Letter to : Mr. Peter McManus [?]  
from : Honorary Associate Professor Winsome Evans, BEM, OAM  
dated : November 7th, 2013  
regarding : Modification Request for the  
University of Sydney  
Abercrombie Precinct Redevelopment  
application no : MPO7\_0158 MOD 3  
abstract : Reasons for strong objection  
to the nature and content  
of the proposal

current proposal by the Uni. of Sydney to modify their plan for the Student Accommodation component of their Abercrombie Street Precinct Development (MPOZ-0158).

Ground Floor Plan
1:200@A1
11.10.13
4001_DA02-D

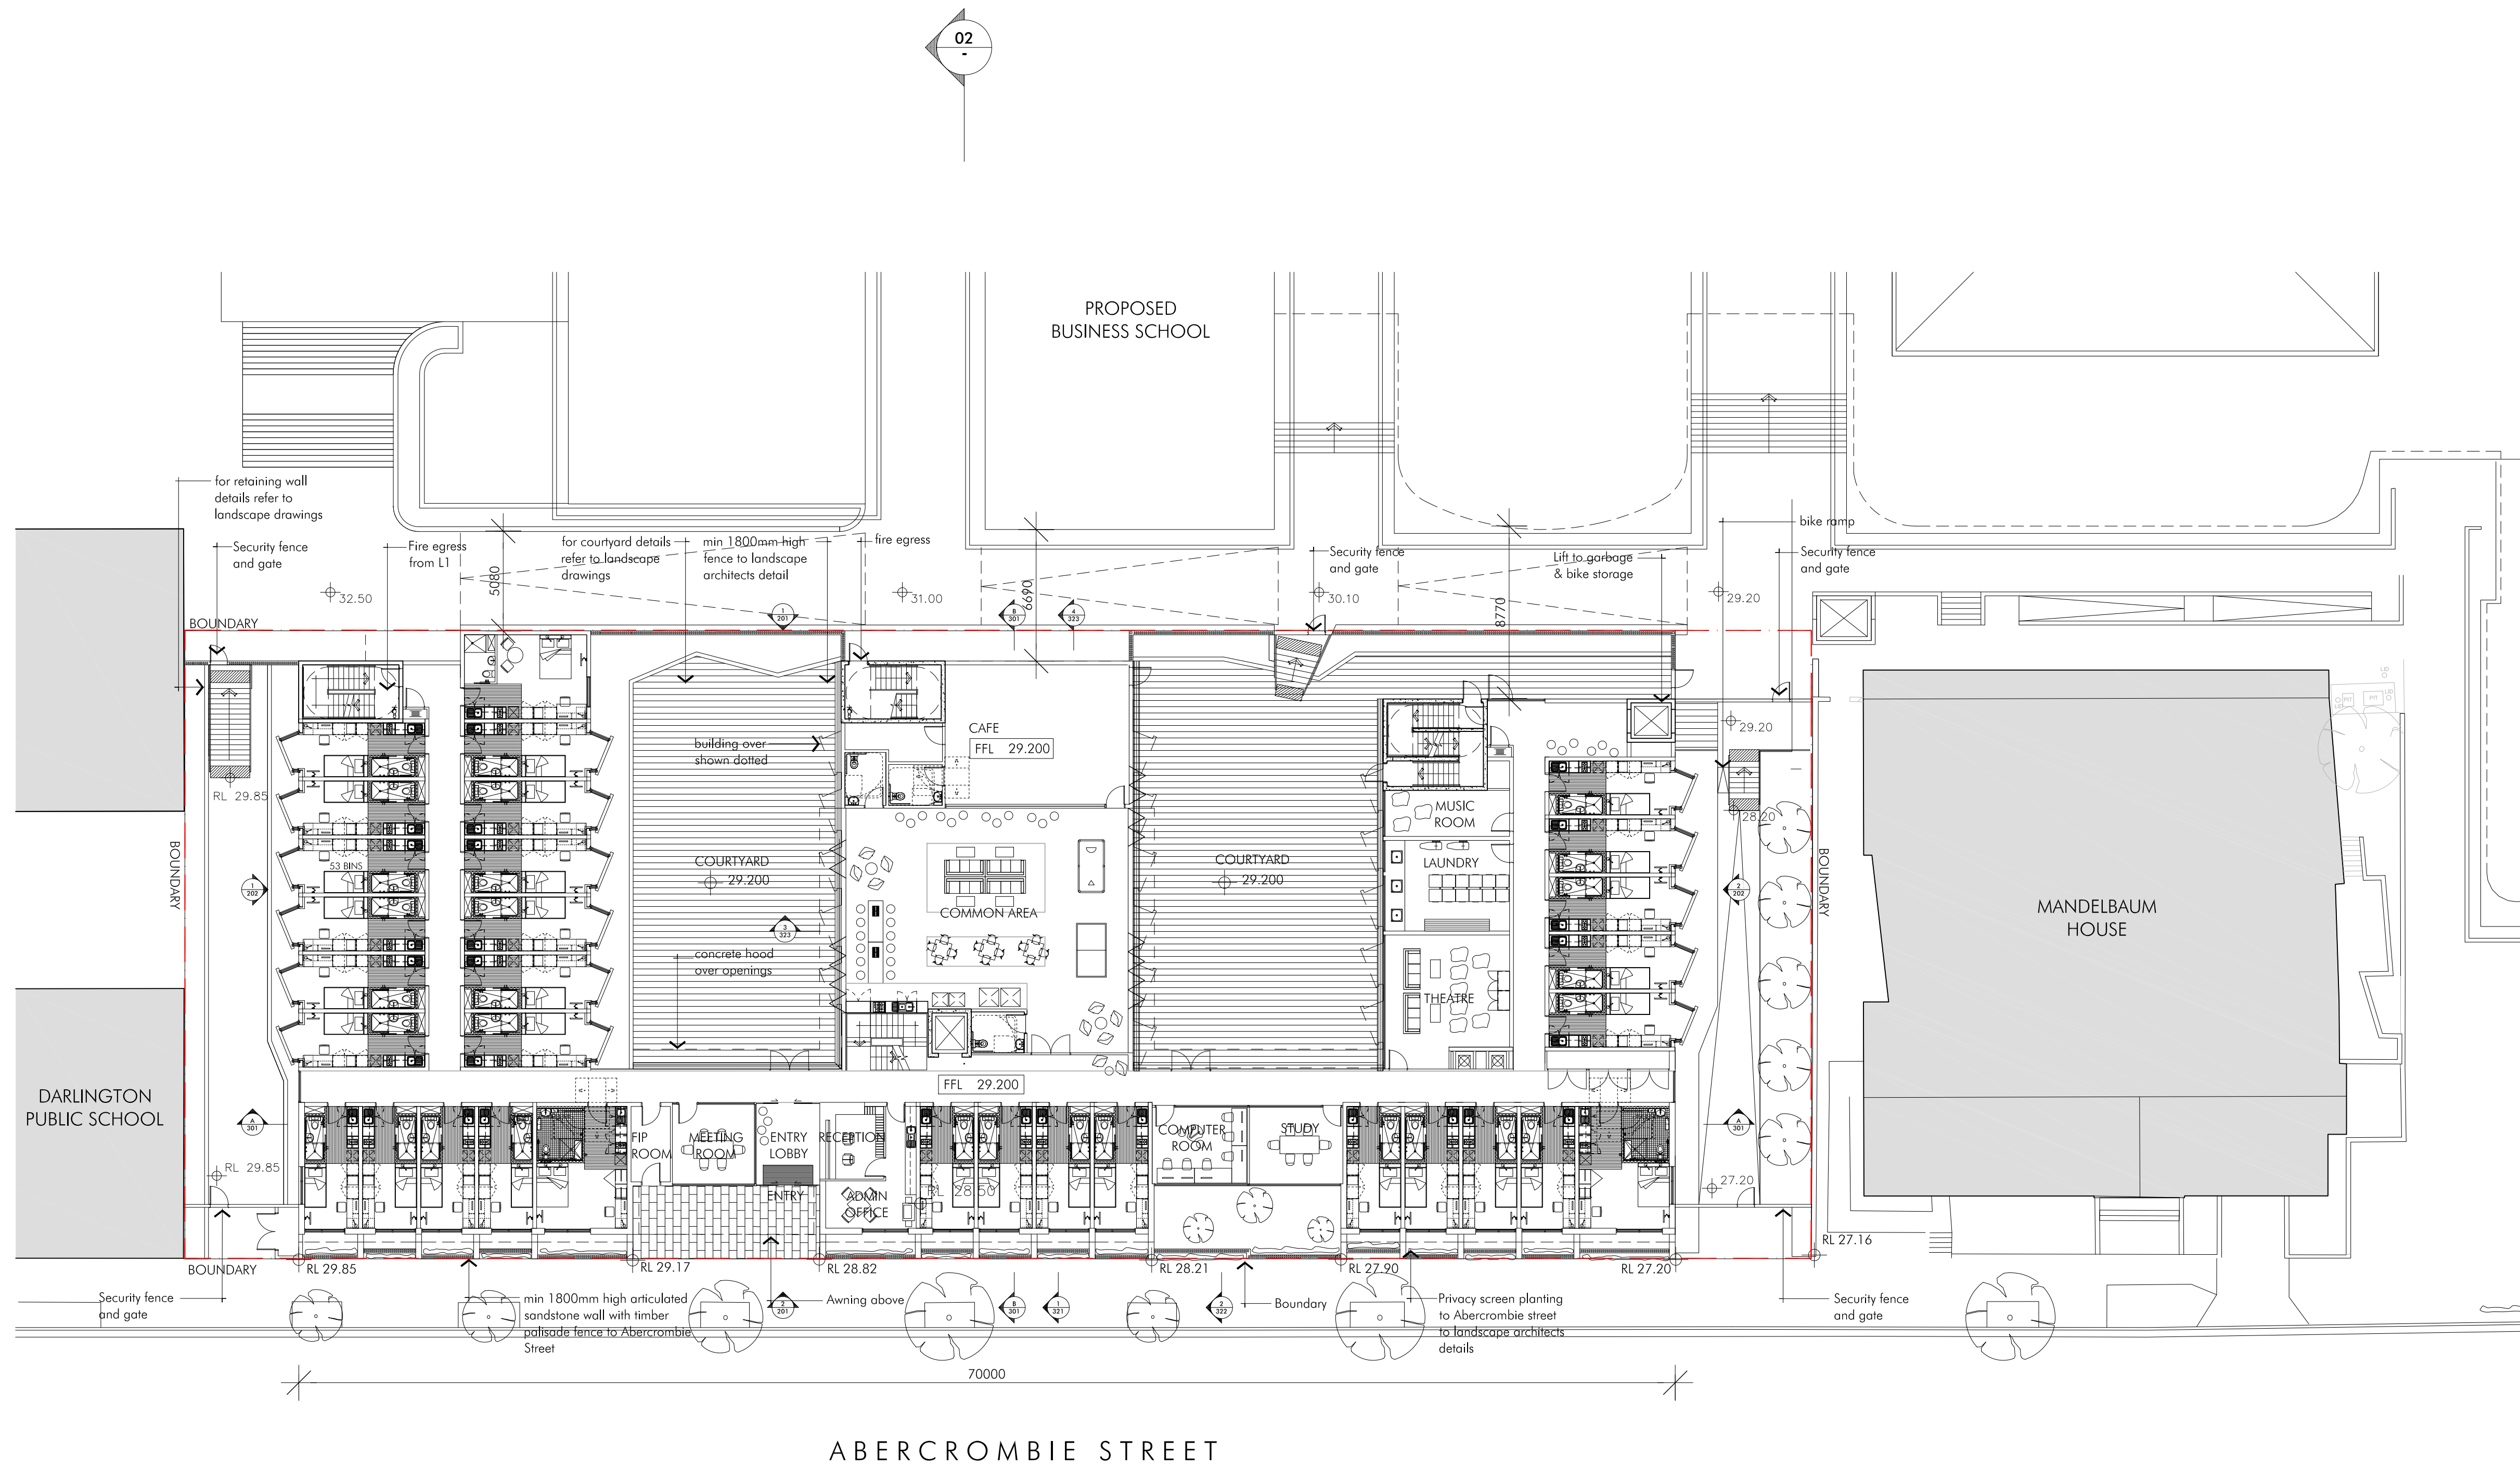
(4) The earlier "concept" plans for a "yet-to-be-finalised - Stage 2" development (which, as already noted, S.Uni. has craftily sailed beyond...) showed a building "block" (no design) set further back from the footpath. This setback must be restored!

(6) The Student Accomodation must be setback as originally planned with dense shrubs, foliage, small trees, etc. to soften the current proposal's stark and too propinquous facade.

(10) ~~20~~50, please set back the front of the building and restore the original accomodation numbers (i.e. 188 not 200);

02 ELEVATION SOUTH (ABERCROMBIE STREET)
SCALE 1:200

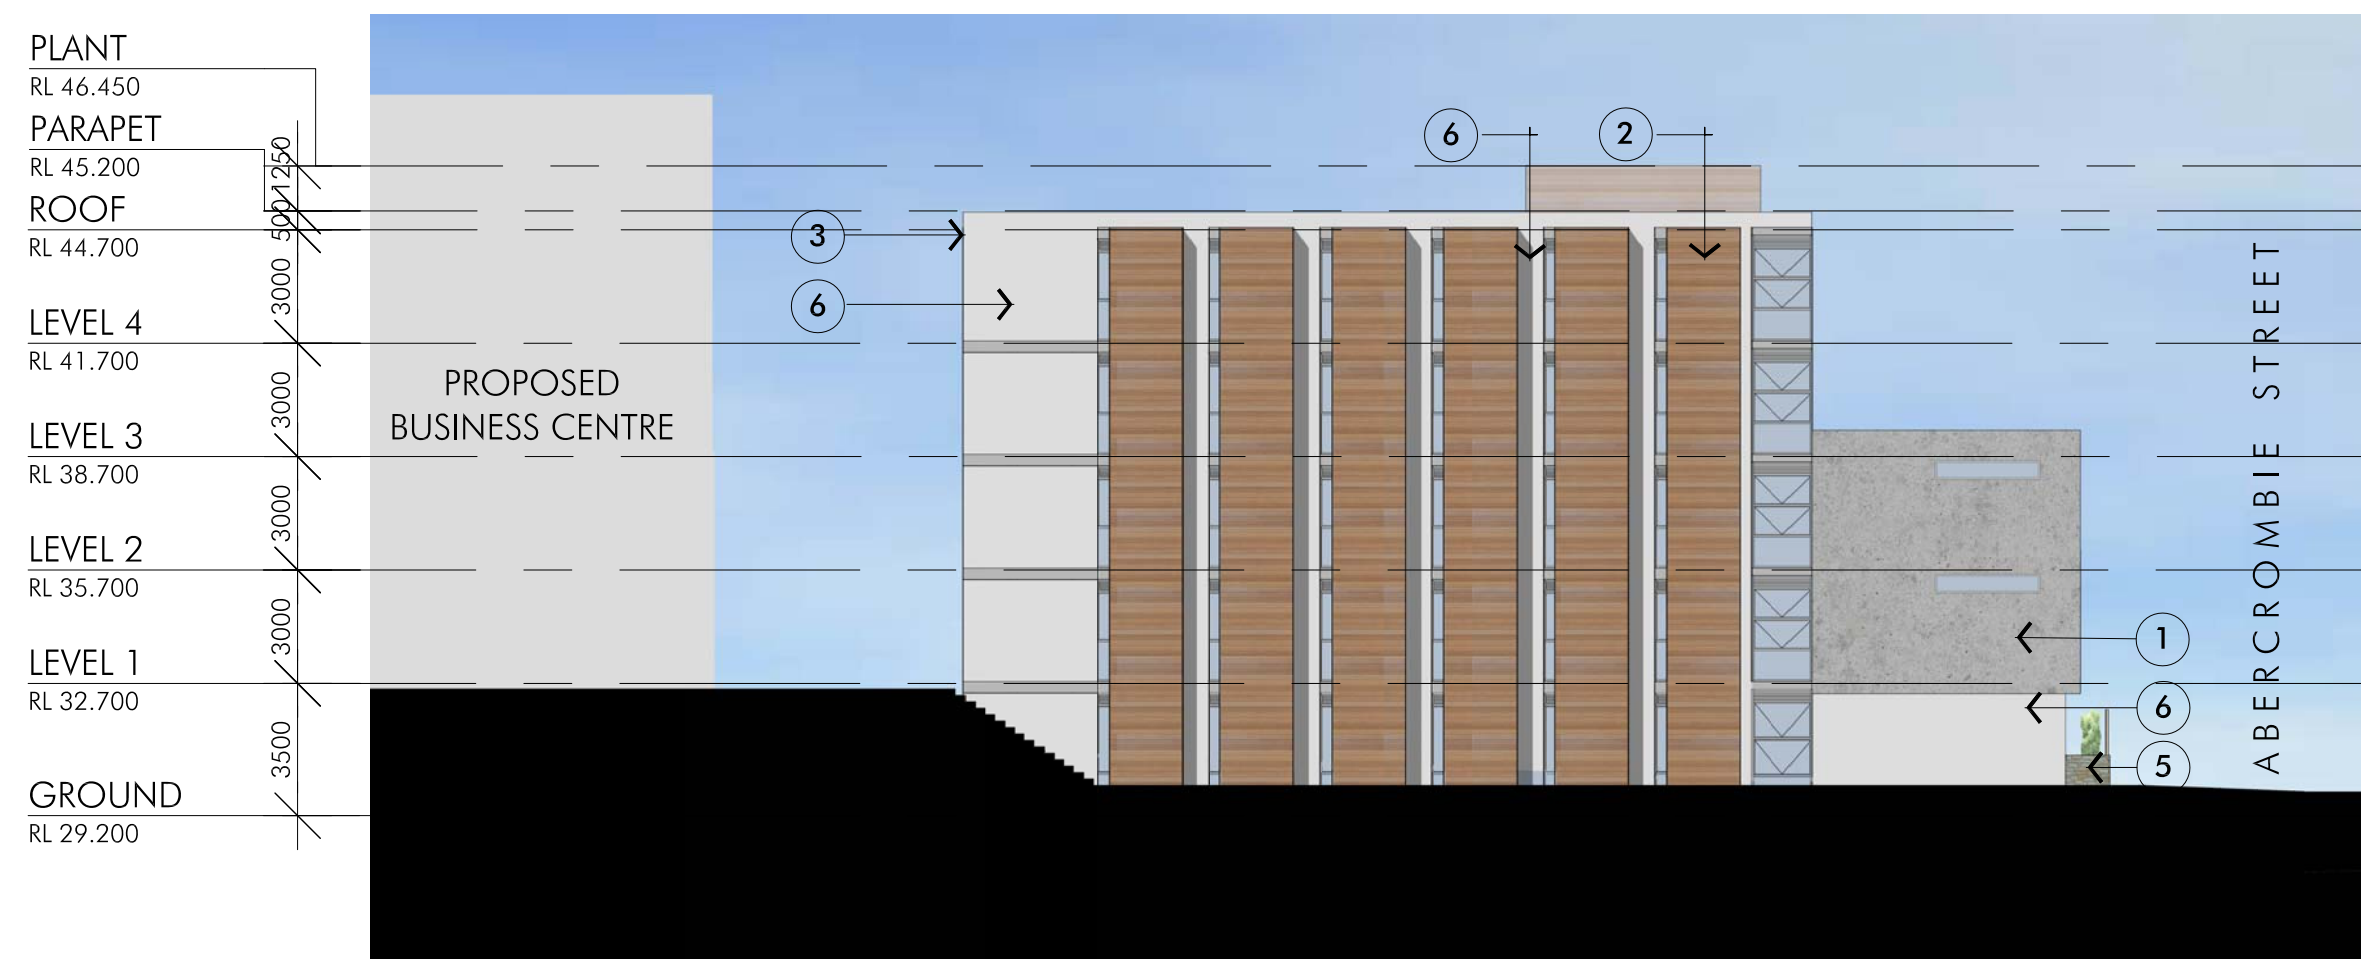
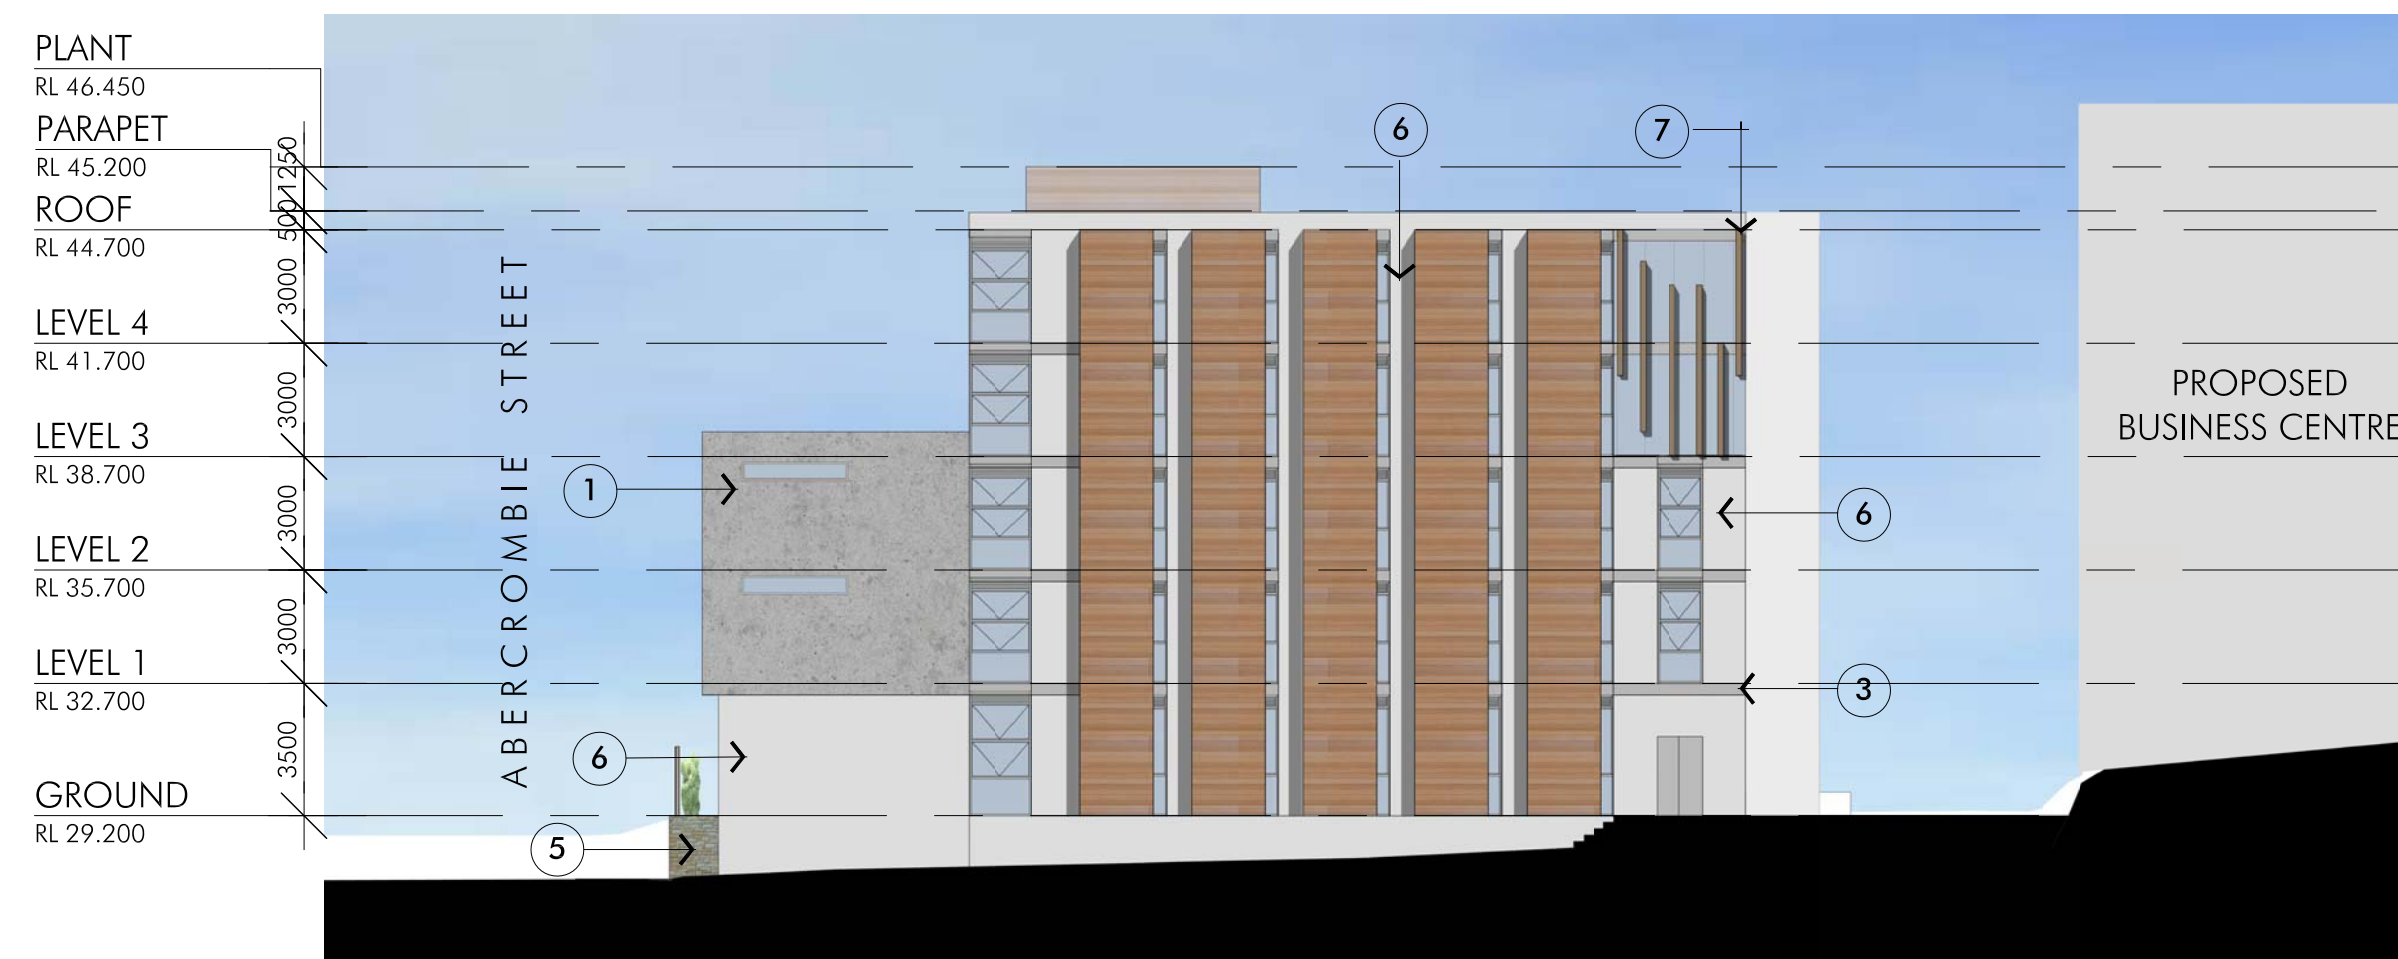
(1) The building is too tall - overpowering the Darlington School and Mandelbaum House, and all the terraces across the road (even my 3-story one)!

(2) The style of the architecture does not suit the heritage terraces (in all their variations)! it looks like library shelving (? Fisher Library's rejects?)!

(3) Furthermore, its design does not blend well (not only with the above)

but, more especially, with the far superior and gently creative ambience of Mandelbaum House (surely S.Uni. can devise a more suitable exterior?)
